REQUEST

Current Zoning: ML-2 (Manufacturing & Logistics – 2)
Proposed Zoning: NC(CD) (Neighborhood Center, conditional)

Approximately 1.53 acres located on the north and south side of 28th Street and the east side of North Church Street, west of North Tryon Street.

The petition proposes to allow uses permitted in the Neighborhood Center zoning district with exception of auto-centric uses among others as specified in the conditional plans. The rezoning is comprised of four parcels, two of which are developed with vehicle repair facilities and two of the parcels are vacant.

**SCHEMATIC  
SITE PLAN**

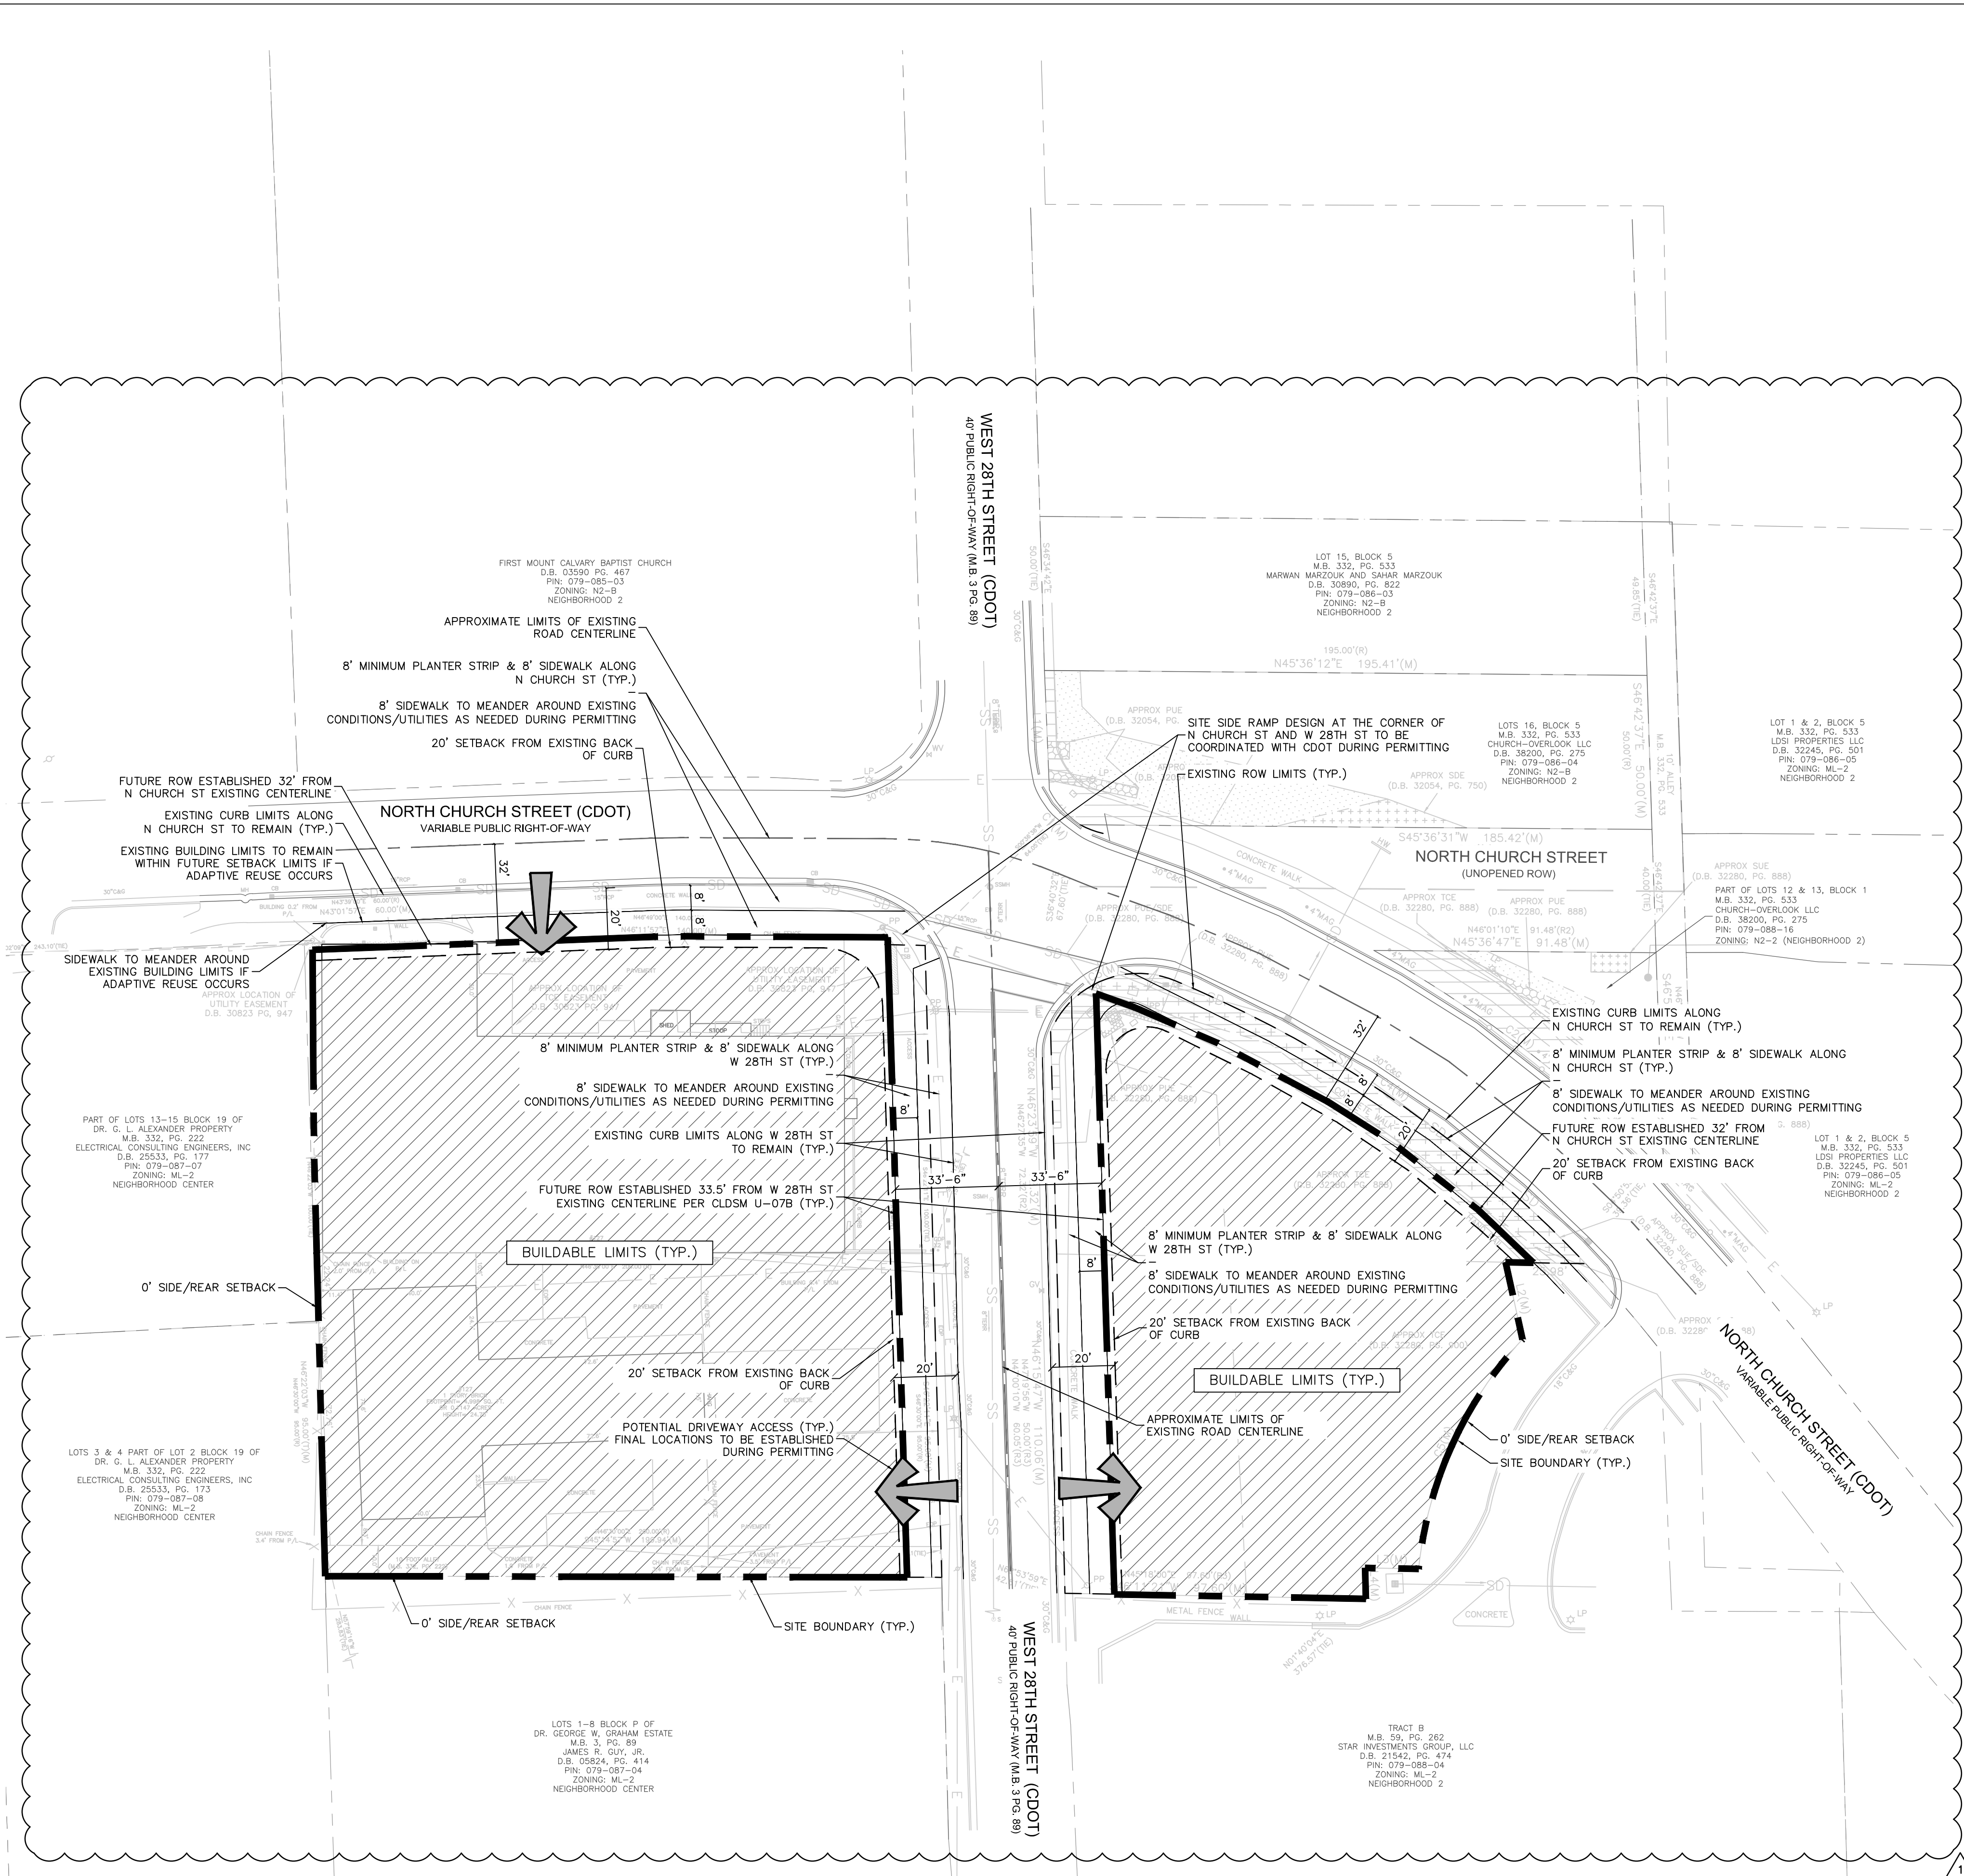
- ~~1. Revise Environmental Features conditions to note that the "development shall comply with Article 25 of the UDO, Post Construction Stormwater Regulations."~~ **Addressed**

- ~~2. Revise the vicinity map to match the rezoning boundary of the four parcels.~~ **Addressed**
-
